4 October 2019

SF2017/281844; WST17/00198/04

SSD-8895: Lots 75-84, 88, 119-121 DP 2987, Lots 1&2 DP 1104720, Lot 3 DP 976701, Lots 1-3 DP 808748, Lot 100 DP 750760, Lot 1 DP 1206579 and Lot 1 DP 664645 Goolma Road (MR633), Wellington; Wellington North Solar Farm; Amendment Report

Figure 2-1 Updated proposal layout.

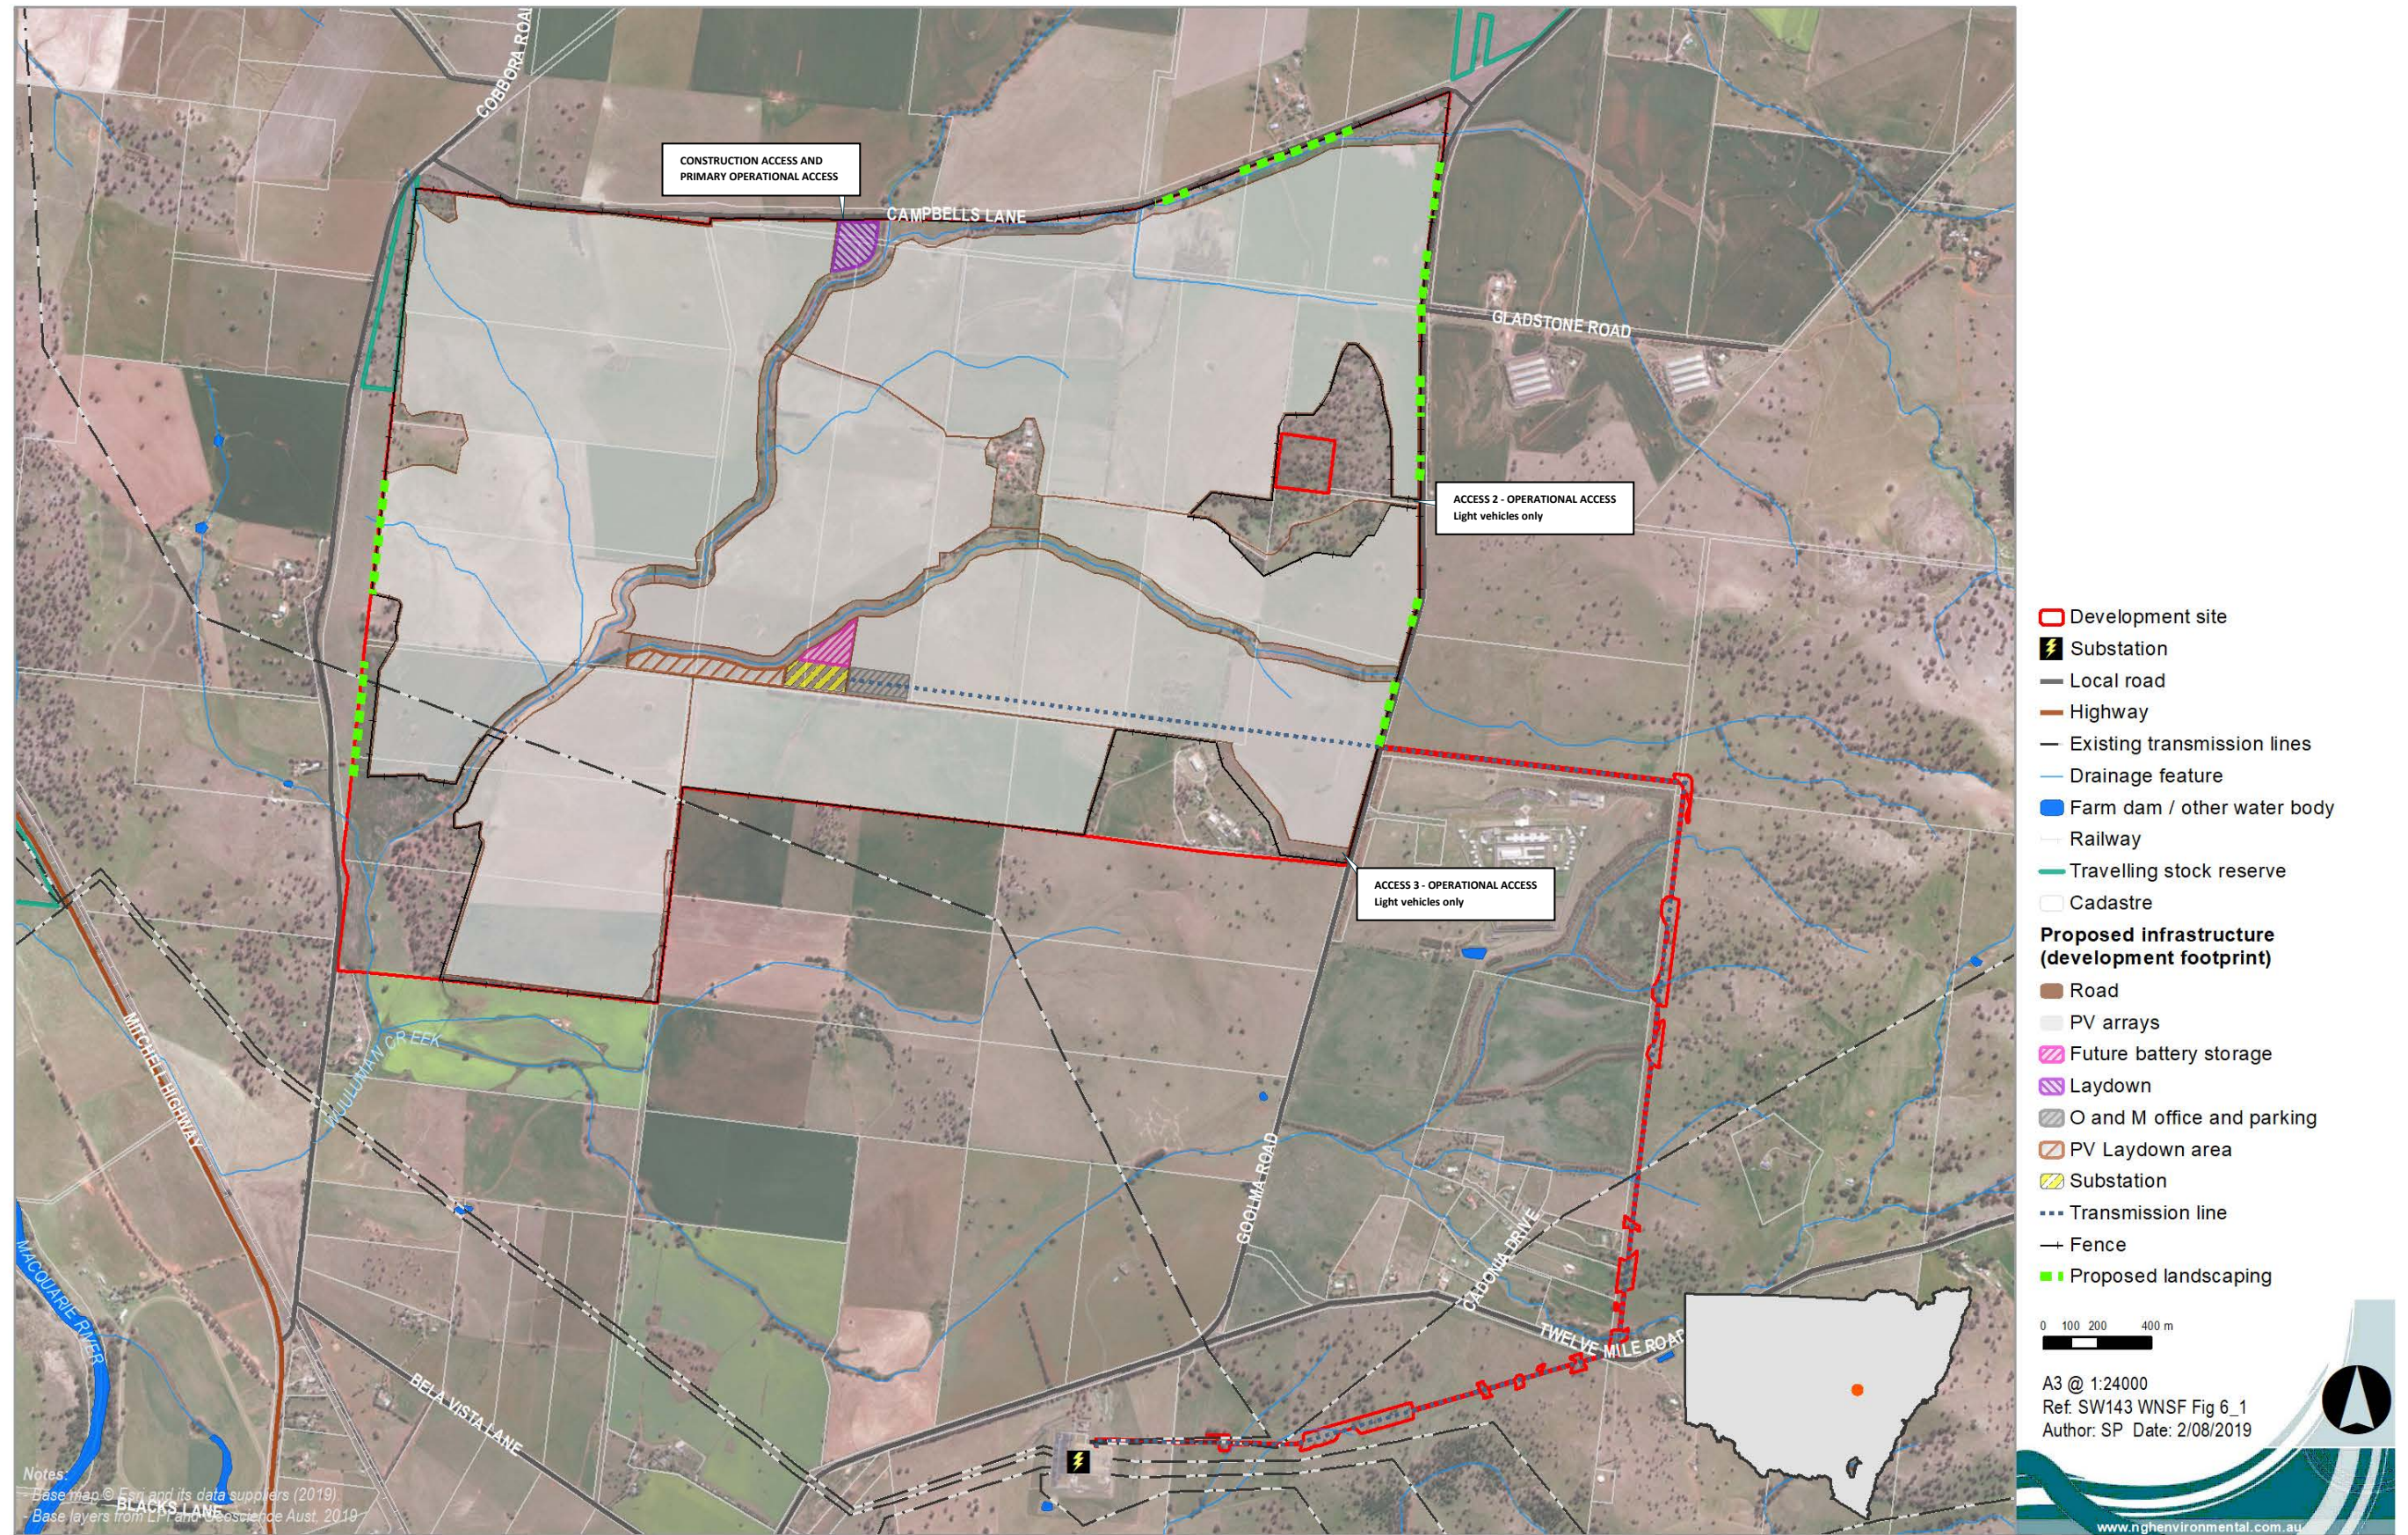
- The Transmission Line Route is now proposed to be constructed via a new eastern option that was not described or assessed in the original EIS.
- The transmission line that will connect the solar plant to the existing Wellington Substation would be a 132kV or 330kV overhead transmission line. From the solar plant site, the transmission line would cross Goolma Road (MR633), approximately 400m north of the Soil Conservation Service site access. It would then continue east for approximately 1.1km to the eastern side of the Wellington Correction Centre, before heading south to Twelve Mile Road for approximately 2km. It would cross Twelve Mile Road and enter the Wellington Substation from the east.

- The transmission line would have an easement up to 60m wide and involve three different land owners.
- It was noted that the construction of the transmission line would result in less traffic along Goolma Road and Twelve Mile Road than originally proposed

- Prior to construction, detailed design works within the classified road reserves will need to be submitted and approved by Roads and Maritime for concurrence pursuant to Section 138(2) of *the Roads Act, 1993*. This included transmission line work within Goolma Road (MR633) a State Classified Road.

- Above ground structures in roads including transmission line poles or towers are to be located as per Roads and Maritime's Requirements for Overhead Power Lines (see copy attached), and:

- Are to be located as far as practicable from the road, and outside the clear zone as set out in *Austrroads Guide to Road Design Part 6: Roadside Design, Safety and Barriers*, which at this location along Goolma Road could be in the vicinity of 10m from the edge of the traffic lane. If the road reserve is not wide enough to locate poles outside the clear zone, it may be necessary to design the poles to be frangible or otherwise locate poles within private property.

- Minimum heights (clearances) above the road surface are to be no less than those set out in the attachment or the energy providers requirements (whichever is greater), plus an additional 1m to allow for future pavement overlays.

- The proponent is to engage suitability experienced surveyor and / or solicitor to review the physical location of the proposed transmission line relative to the road and any rail corridors and existing cadastral boundaries.

- Any creation of easements in favour of the private transmission line operator is generally not supported by Roads and Maritime including any lease which would burden the public domain for a private purpose. Should this be considered as part of the transmission line option, there is to be no inhibition of the powers of Council or Roads and Maritime in ensuring the safety, efficiency or integrity of the classified road network (being Goolma Road) and the travelling public.
